Response to Planning application from Hertfordshire County Council (T and CP GDP Order 2015)

District ref: 6/2021/1177/FULL
HCC ref: WH/7065/2021
HCC received: 11 May 2021
Area manager: Matthew Armstrong
Case officer: Paul Marshall

52 BRIDGE ROAD WELWYN GARDEN CITY AL8 6UR

Erection of 2 x two-storey detached houses, associated parking and access, on the land to the rear of 52 & 54 Bridge Road

Project: RO Bridge Road, 52&54 AL8 6UR
Client: Mr. M. Tabrizi
Title: Proposed Site Plans and Elevation
Scale @ A1: As indicated
Drawing No: 1644.P.02

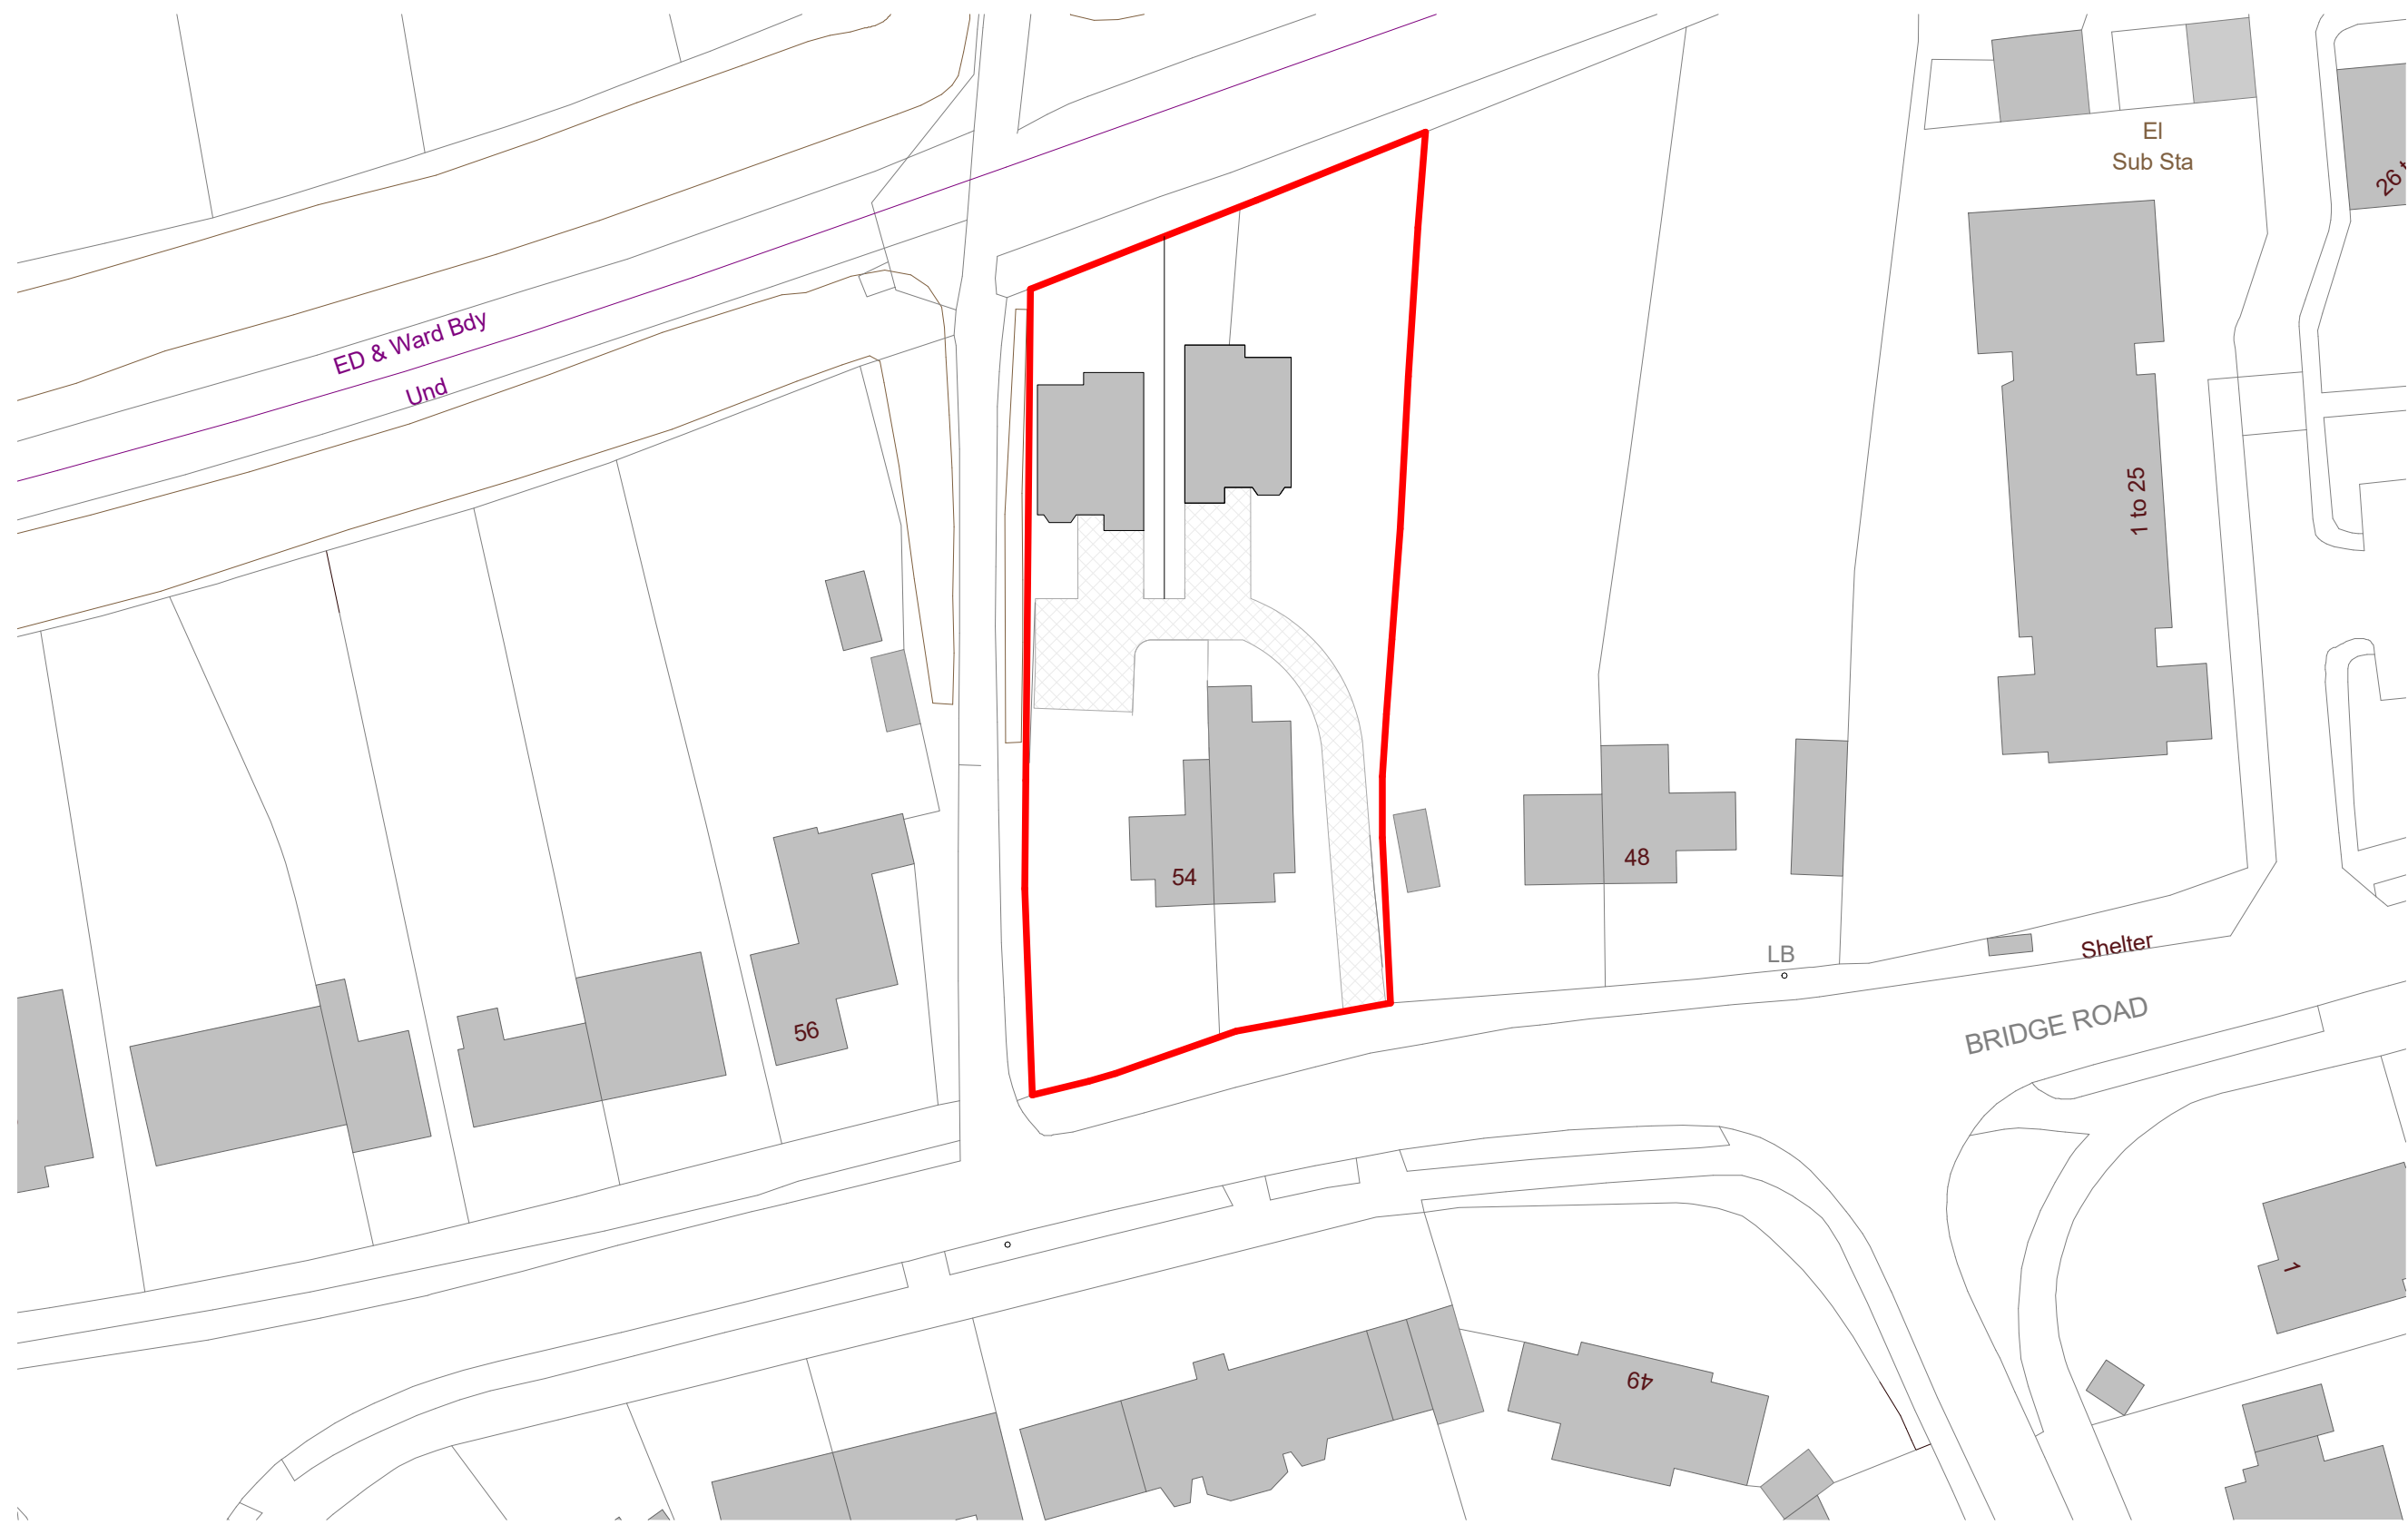
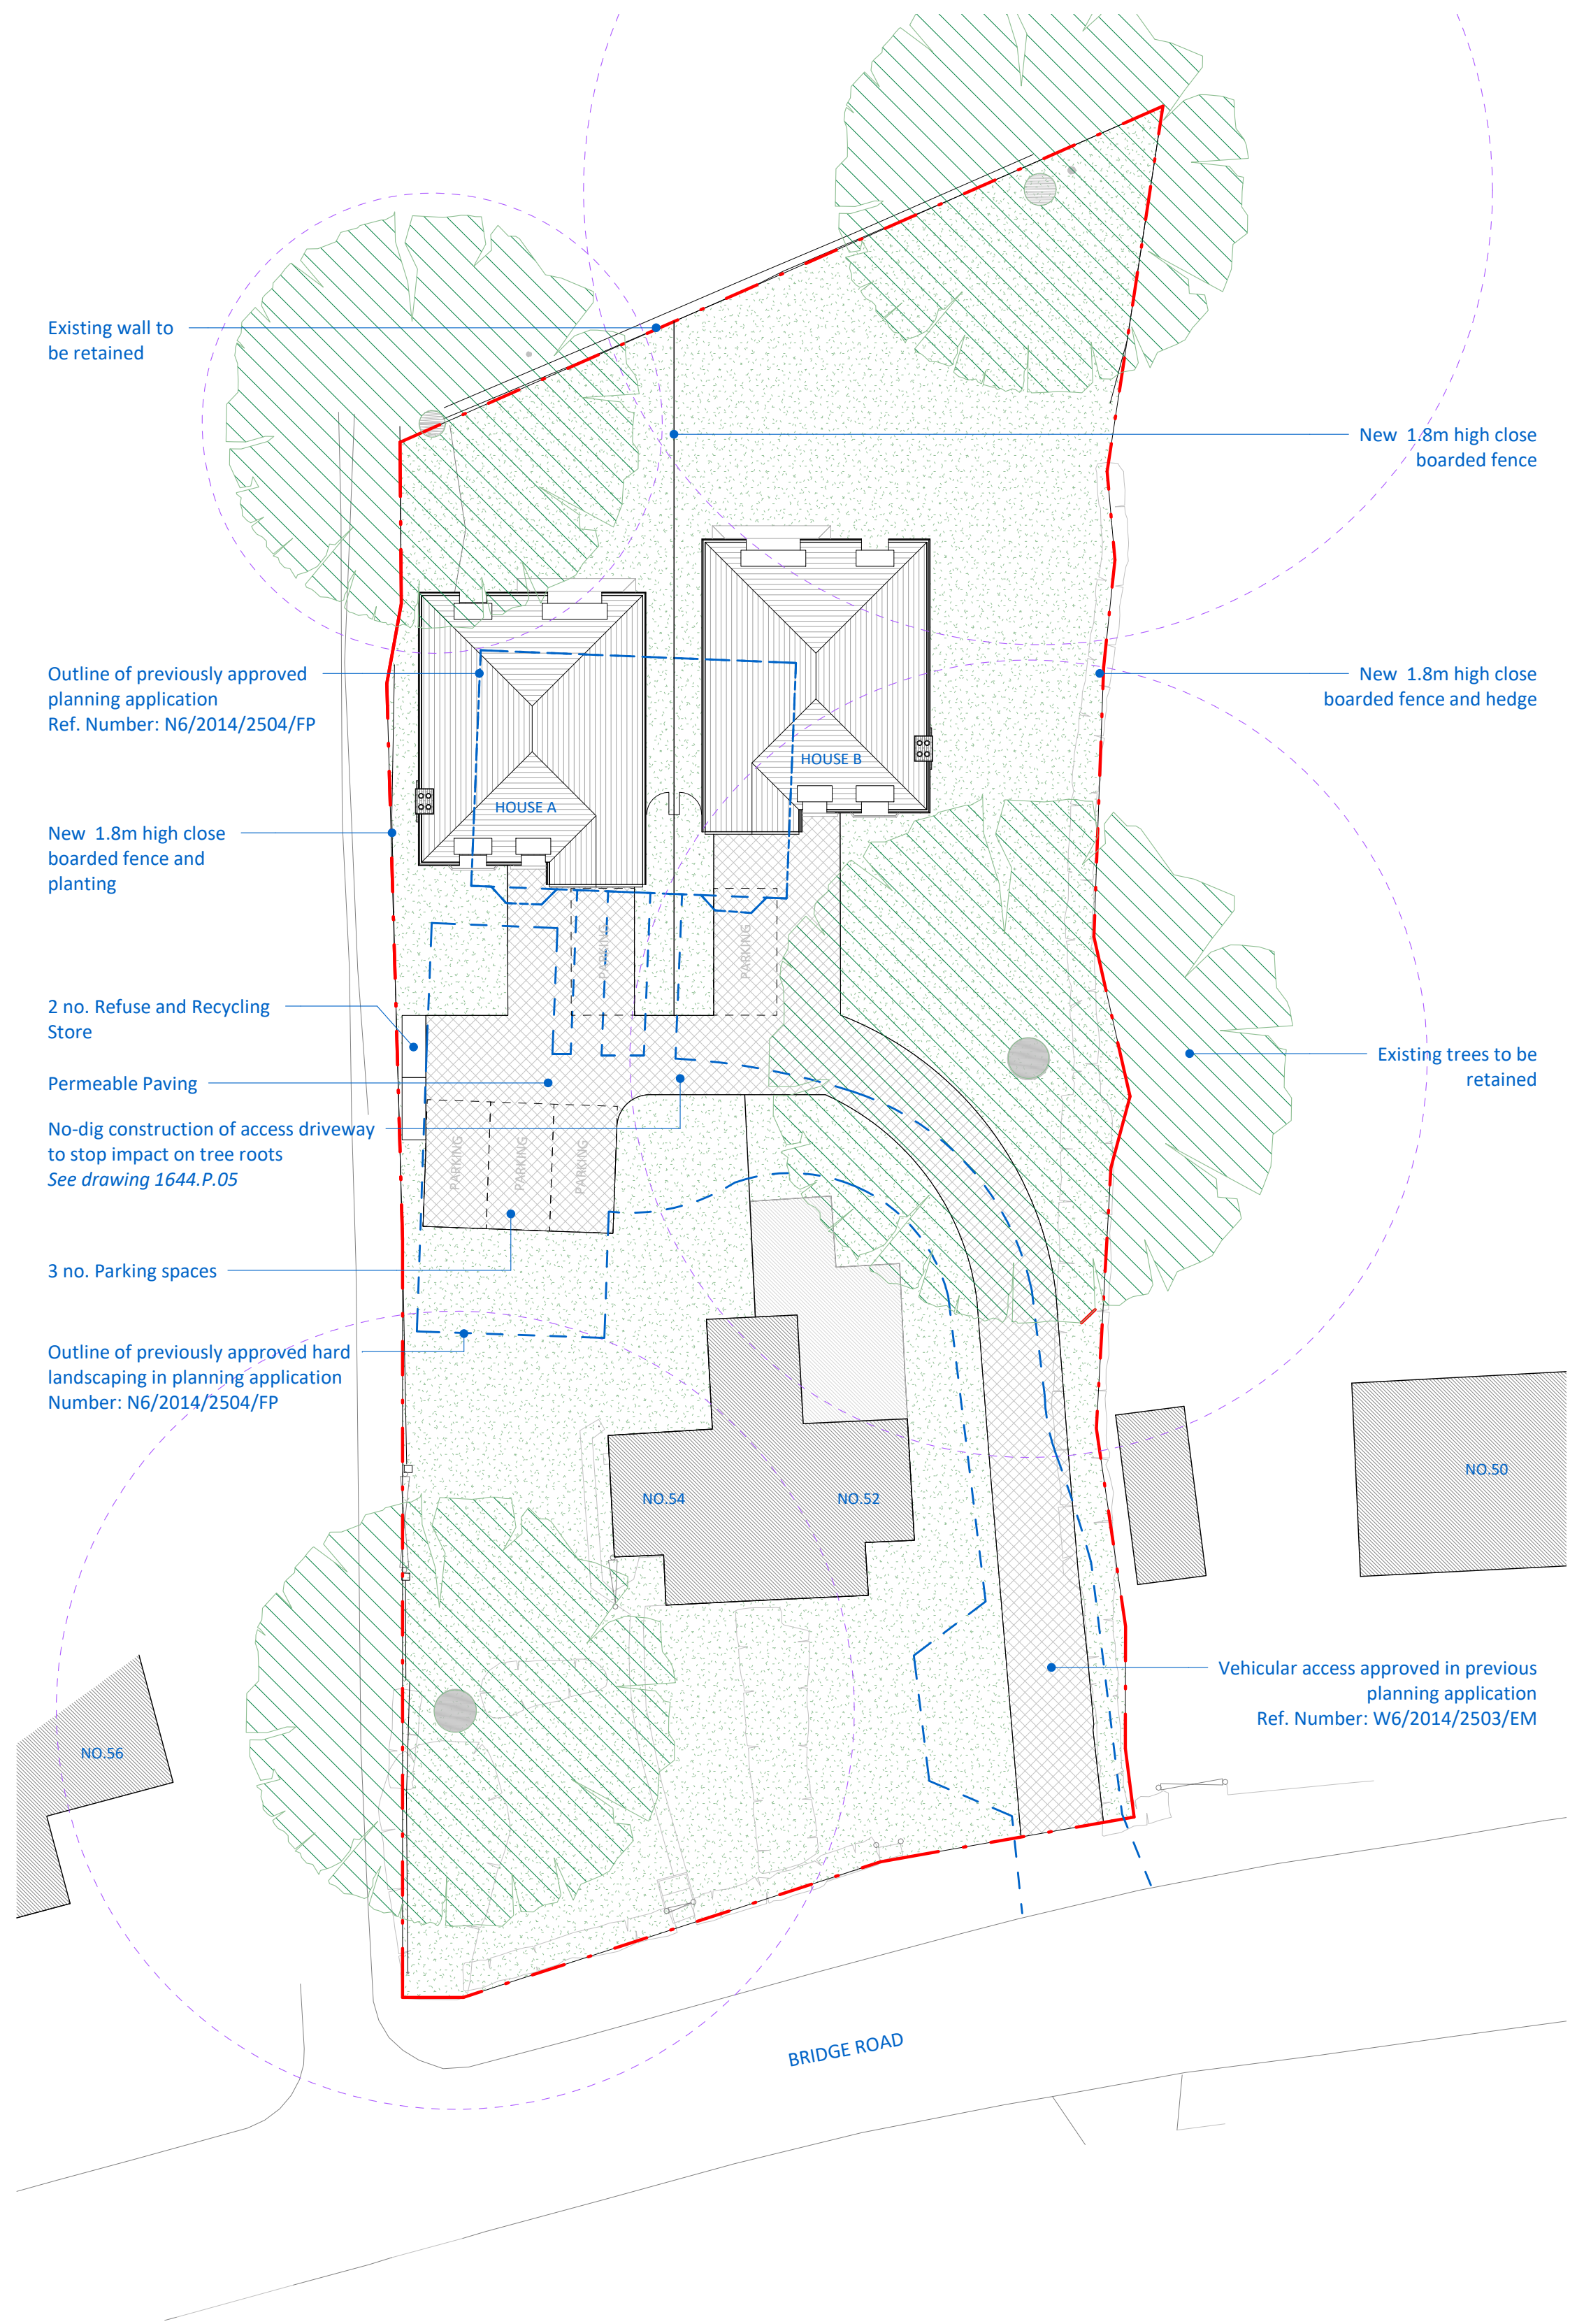
New cycle standards have recently been published 'Cycle Infrastructure Design' Local Transport Note 1/20 July 2020. Section 11 recommends the length required to park a cycle should be 2m however, 1.8m is acceptable, there should be 300mm space between each parked cycle. Outside storage should be covered and lockable. There should be 1 cycle parking space per dwelling. No storage facilities have been proposed. Please see condition 1

A pedestrian visibility splay should be provided. A triangular vision splay must be provided on each side of the new access and measure 2 metres along the fence, wall, hedge or other means of definition of the front boundary of the site, and 2 metres measured into the site at right angles to the same line along the side of the new access drive. The vision splays on land under the applicant's control must be maintained free of any obstruction within which, there must be no obstruction to visibility between 0.6 metres and 2.0 metres above the carriageway. See condition 4

A vehicular visibility splay must be provided. This should be measured from the back edge of the carriageway (centre crossover) a minimum of 2.4m (x distance) and the (Y distance) a minimum of 43m to the nearside kerb either side of the access. See condition 5

The development provides no bin storage. The current distance of the bins to the carriageway edge is over 40m. Manual for Streets MfS 6.8.9 states: residents should not be required to carry waste more than 30m. A plan detailing bin storage / position must be provided. See condition 6

CON 1) Prior to the first occupation of the development hereby permitted a scheme for the parking of cycles including details of the design, shall be submitted to and approved in writing by the Local Planning Authority

CON4) Before the access is first brought into use by the new development, a triangular vision splay shall be provided on each side of the new access and shall measure 2 metres along the fence, wall, hedge or other means of definition of the front boundary of the site, and 2 metres measured into the site at right angles to the same line along the side of the new access drive. The vision splays so described and on land under the applicant's control shall be maintained free of any obstruction to visibility exceeding a height of 600mm above the adjoining footway level.

CON 5 Prior to the first occupation of the development hereby permitted (or Prior to the commencement of the use hereby permitted) a visibility splay measuring 2.4 x 43 metres shall be provided to each side of the access where it meets the highway and such splays shall thereafter be maintained at all times free from any obstruction between 600mm and 2m above the level of the adjacent highway carriageway.

CON6) Prior to the first occupation of the development hereby permitted recycling bin storage area not more than 30 meters from the edge in the form of plans / drawings shall be submitted to and approved in writing by the Local Planning Authority
